Property located at 4825 East Mercer Way on Mercer Island Washington (King County Parcel #2162000070) is directly north of your property. Plans call for construction of a new house on the property.

This report provides information on several 4825-Property trees and evaluates prior assessments by arborists on the property. Recommendations based on observations and findings are provided. Please see Assumptions and Limitations for this report (**Assumptions and Limitations**).

Installation of a new home on property located at 4825 East Mercer Way on Mercer Island Washington is planned. Due to existing mature trees on the property, exploration to discover the extent of root growth within a potential driveway location was conducted.

1 PROPOSED SITE PLAN
SCALE: 1"=10'

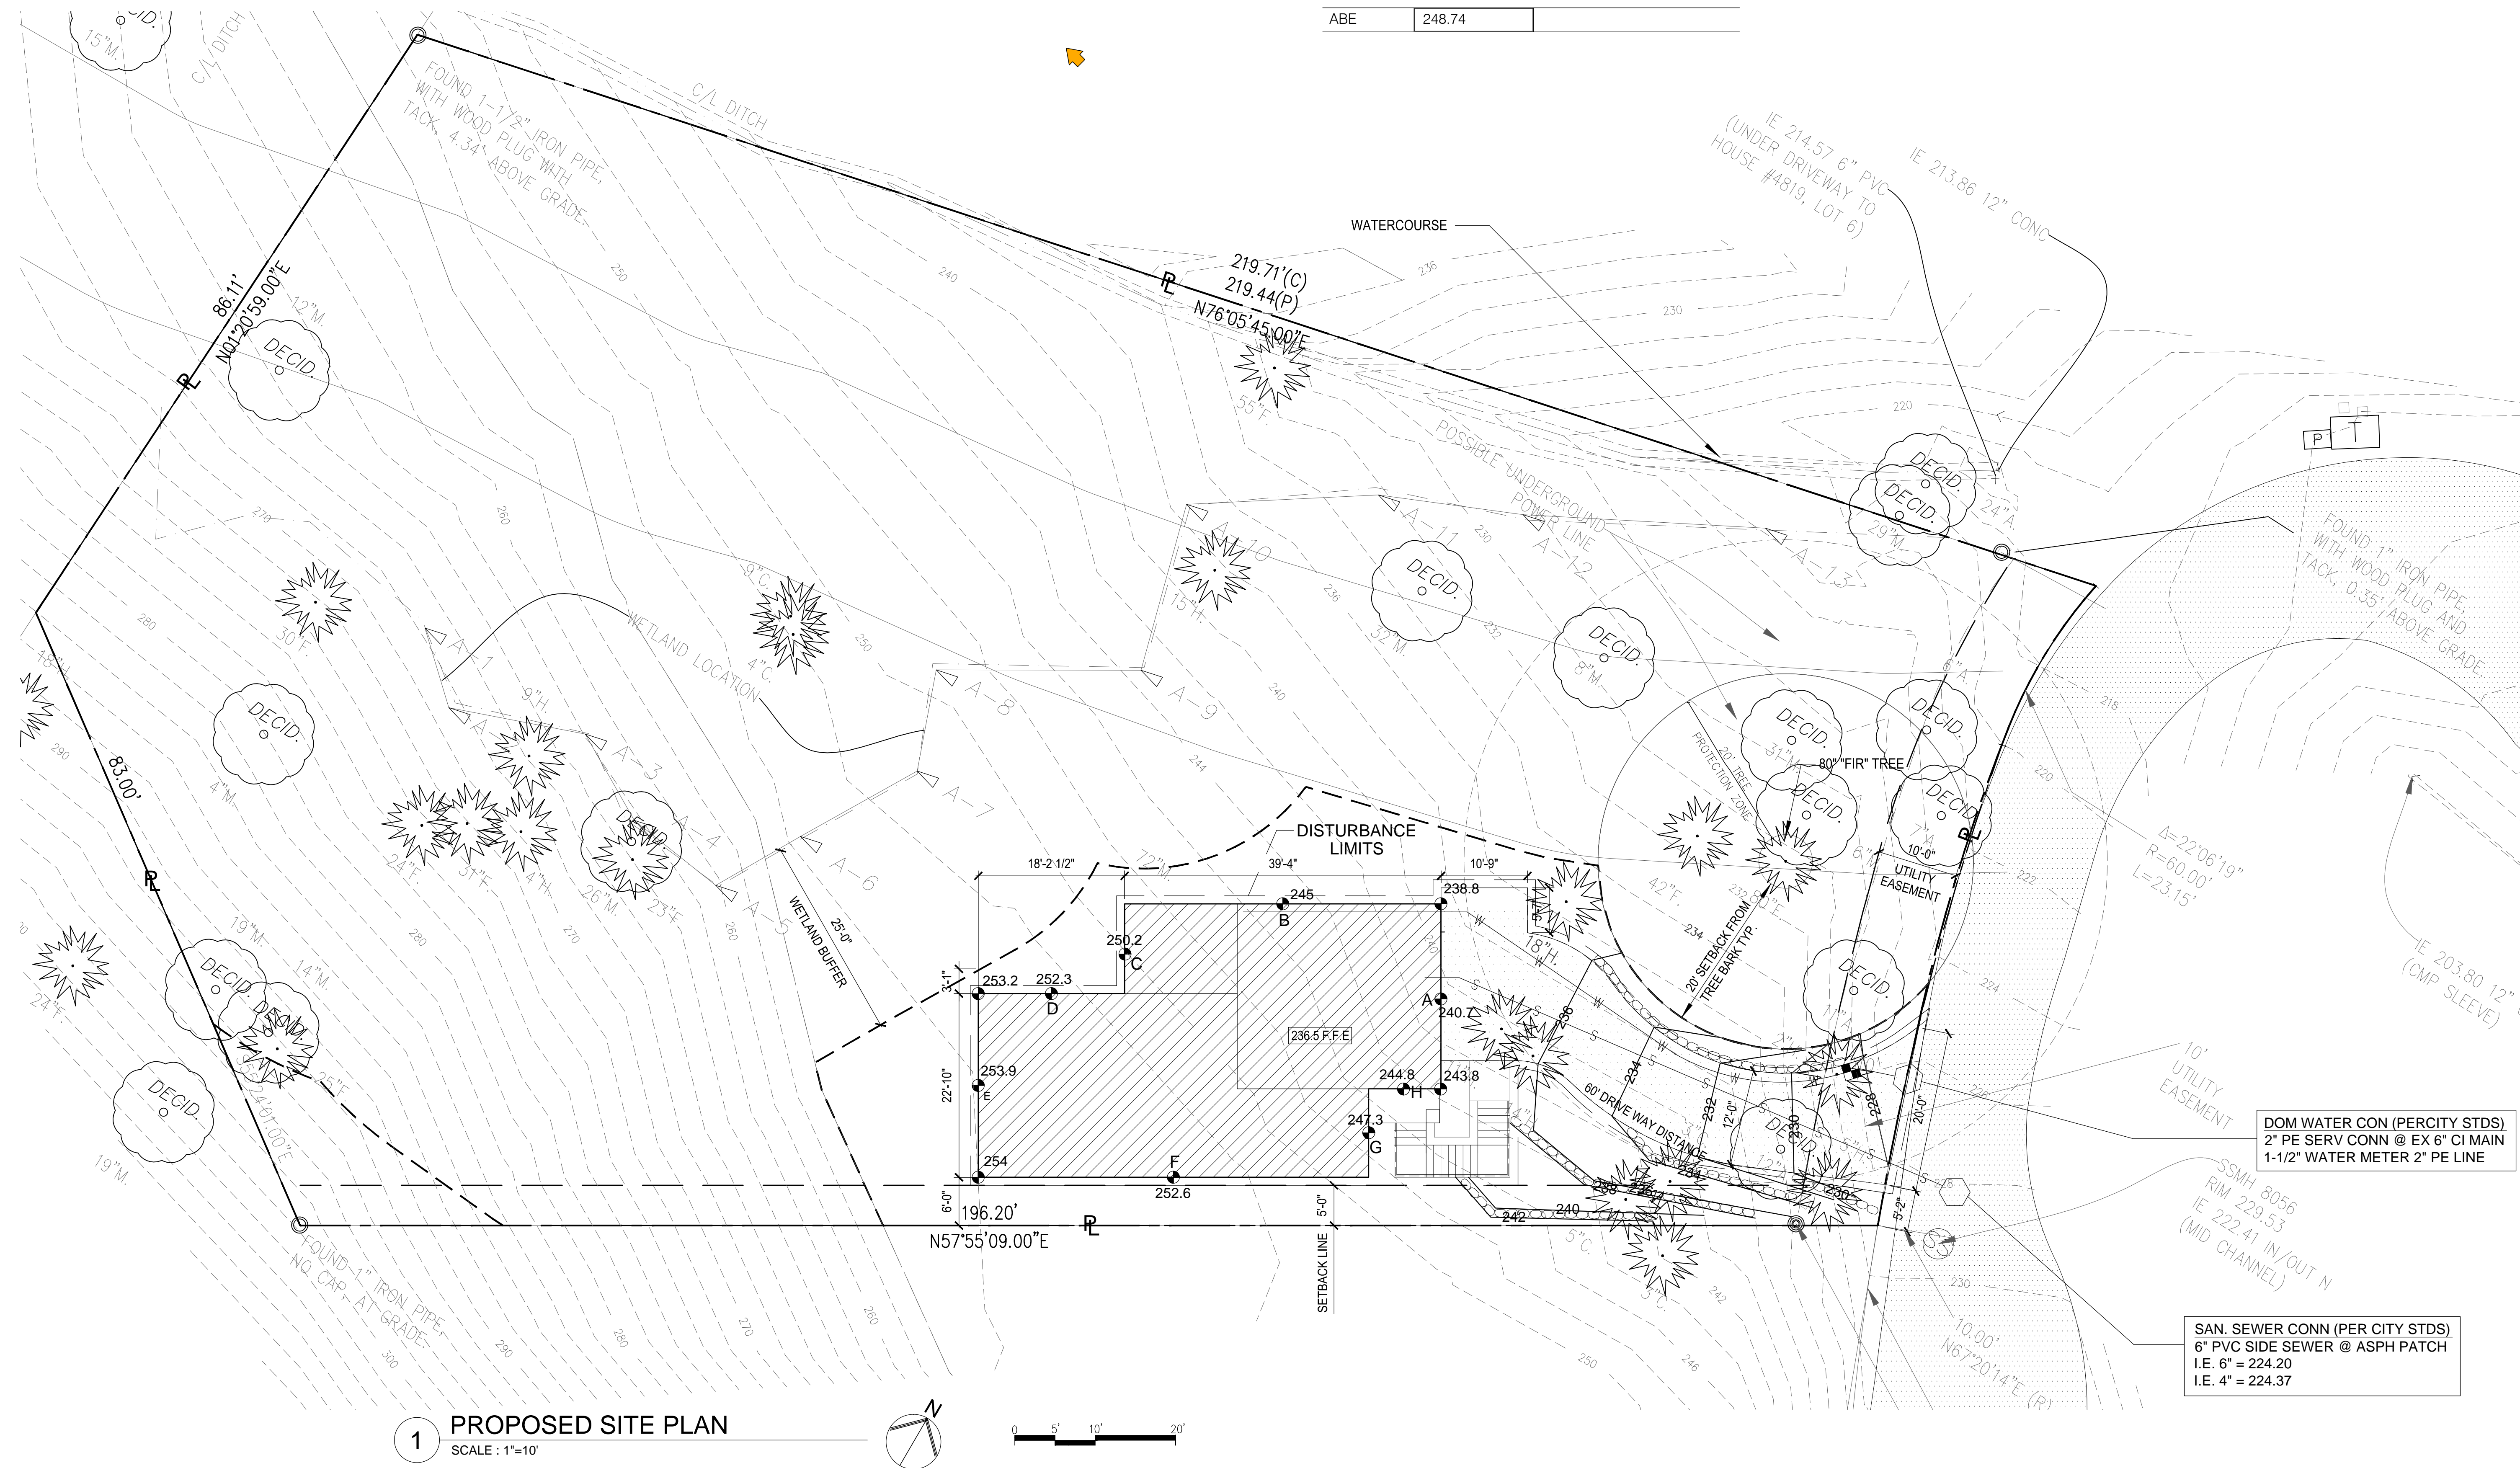
While exploration exposed few roots at 2-feet below grade or deeper in some locations, **unexposed root growth is likely to be present within the area where a new driveway is planned.**

Additional root exploration to deeper depths is recommended prior to project approval.

Placement of a new driveway is likely to require excavation below the upper 2-feet of soil. Tree roots may be present at these depths

While significant tree roots were encountered at depths of 2-feet or less in locations where air spaded trenching took place, significant tree roots are likely present at greater depths and in soil where the new driveway is planned or preferred.

Prior to approving placement of a new driveway in the desired location, additional root exploration is recommended due to likely chances of encountering significant roots.
